Subject: BR/276/21/PL Former Westside Supplies Unit, Durban Road, Bognor Regis

Figure 3.1: Habitats present on the site. See main text for target note descriptions

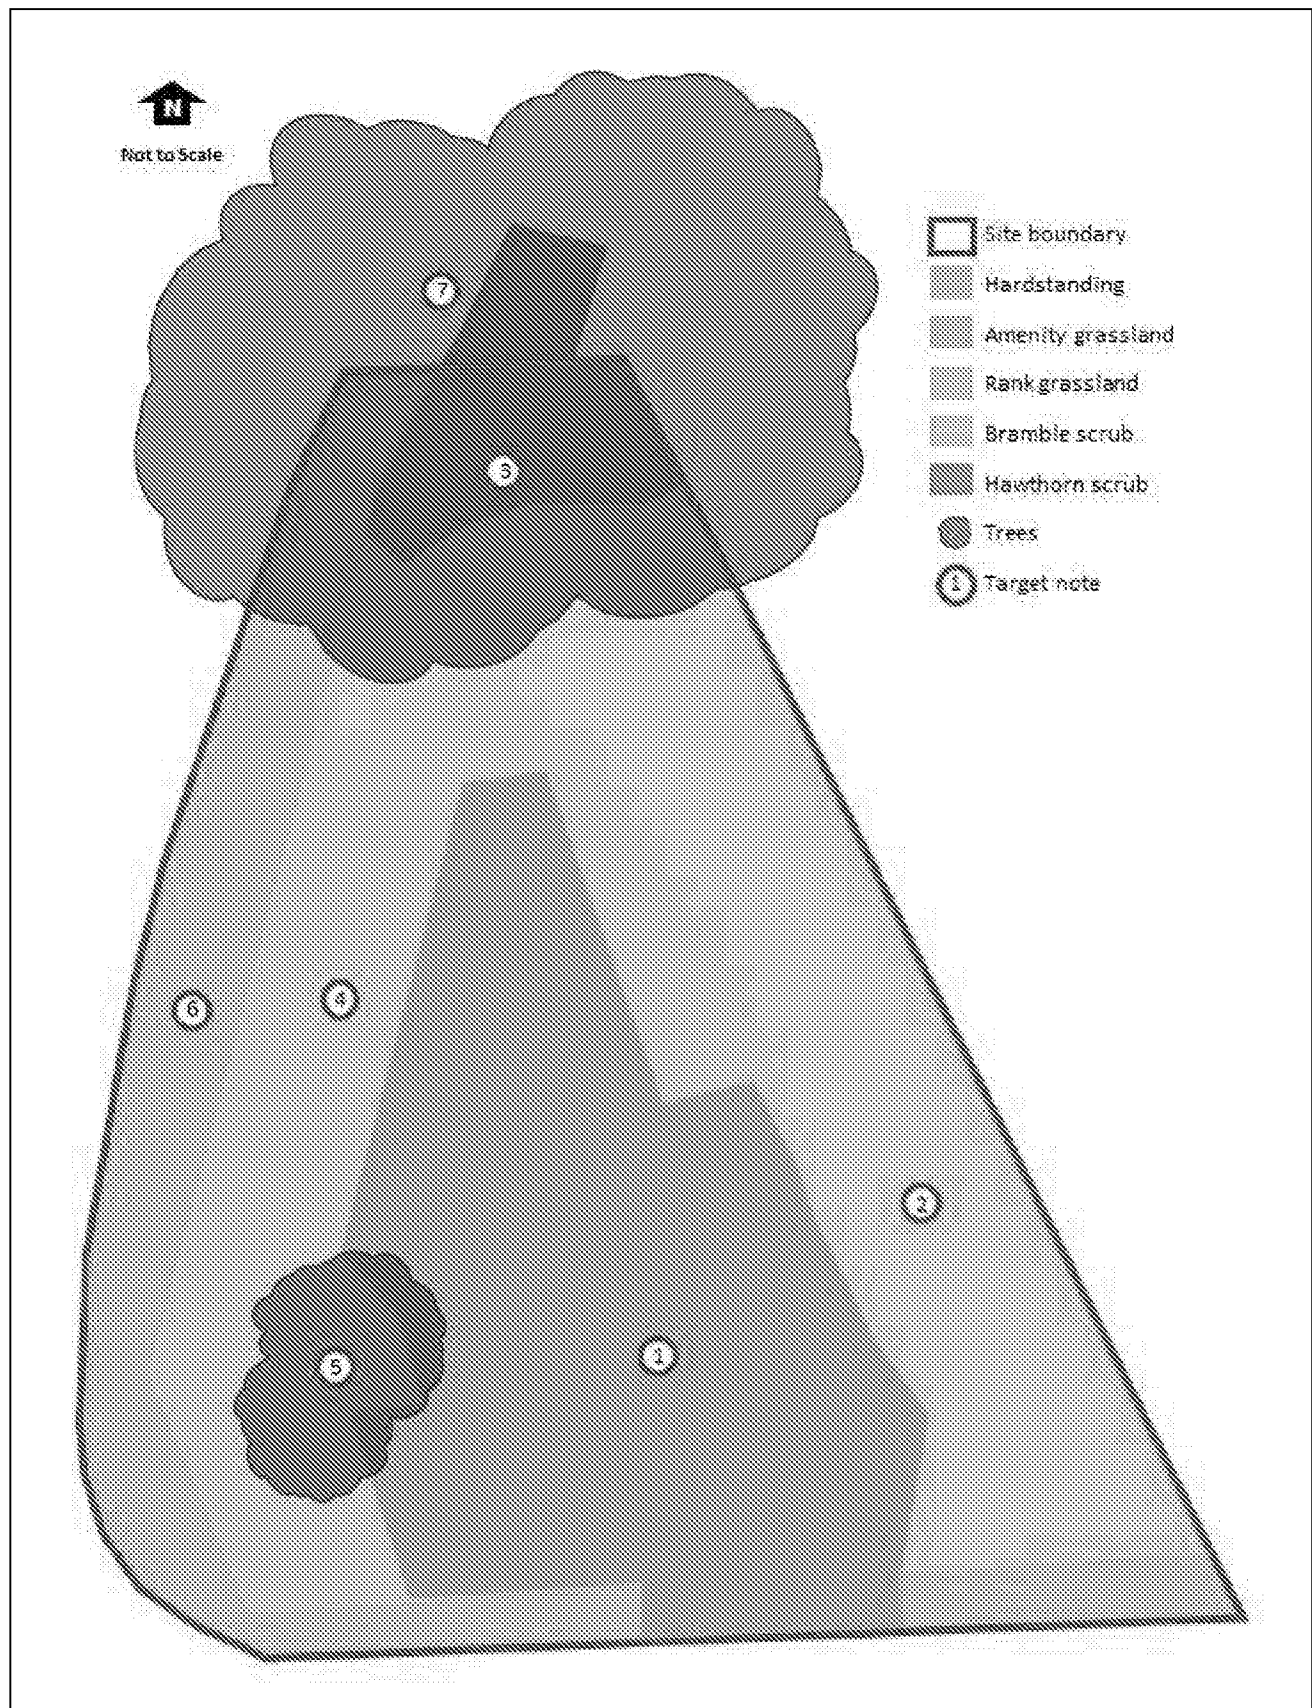
I note that the submitted Ecological Appraisal states at 3.4.2 that *"There are no buildings or trees on the site that are suitable for bats to roost. No suitable roost features were noted on the large willow trees at the northern end of the site, although these were not surveyed in detail. The site may be used by foraging bats, although it is too small to be of significant value."*

However, conversely our ecologist has stated that *"the three mature white willows much be retained as part of this application and safeguarded as per the appropriate British Standards. Mature willows are regarded as being some of the most likely for having bat roosting features"*

I note that the scheme is dependent on the removal of two trees/pruning of the third so any permission would need to sanction their loss and instead seek appropriate biodiversity net gain to compensate for the loss. However, can you get a response from your ecologists to our ecology comment. It would also be helpful if the trees could be surveyed in detail. I look forward to hearing from you.
